**Reference:** A. Dept of Planning Letter of 9 May 06, request for Submissions  
Report re Proposed Capital Wind Farm (PA No. 05\_0179).

Vipac Responses to DEC Questions (Ref S04/01018/1, dated 28/4/06):

FIGURE 10.1
LOCATION OF RESIDENCES AND
BACKGROUND NOISE MONITORING SITES

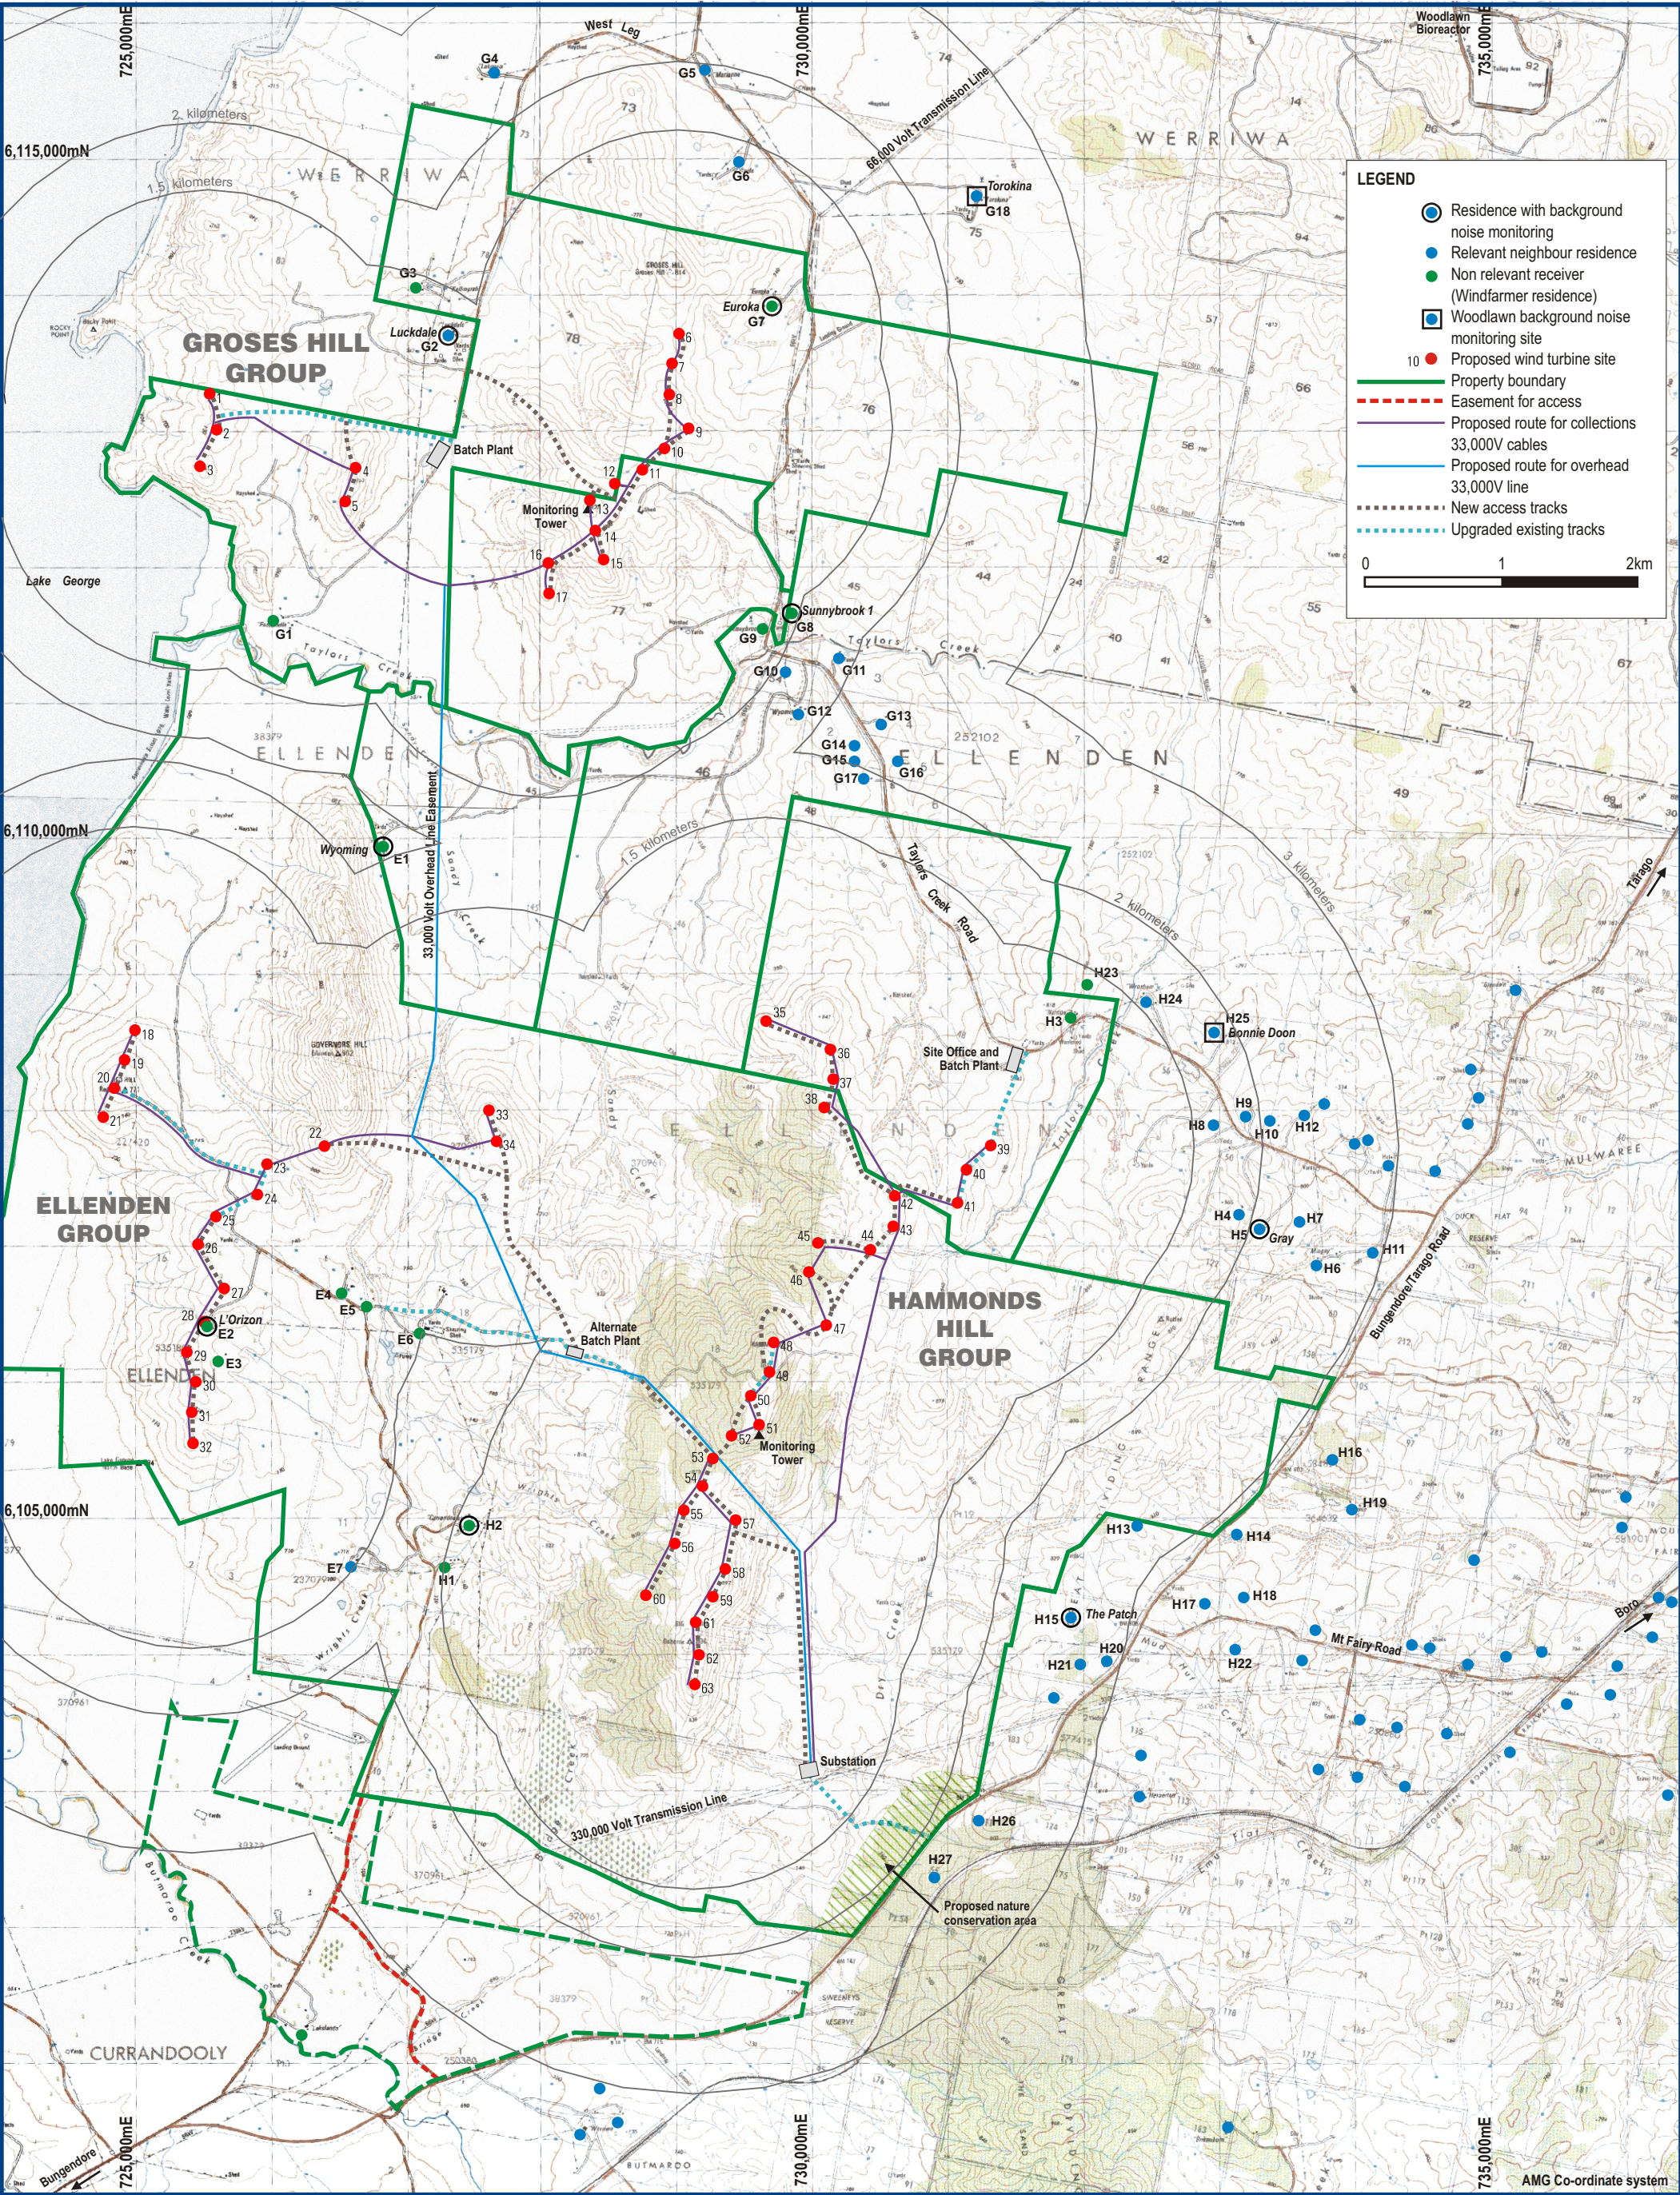
6. DEC also notes that two associated receiver residences are predicted to experience noise levels above World Health Organisation health based noise levels.

VIPAC: These two receivers (E2 & E3) have been purchased/leased by RPV.
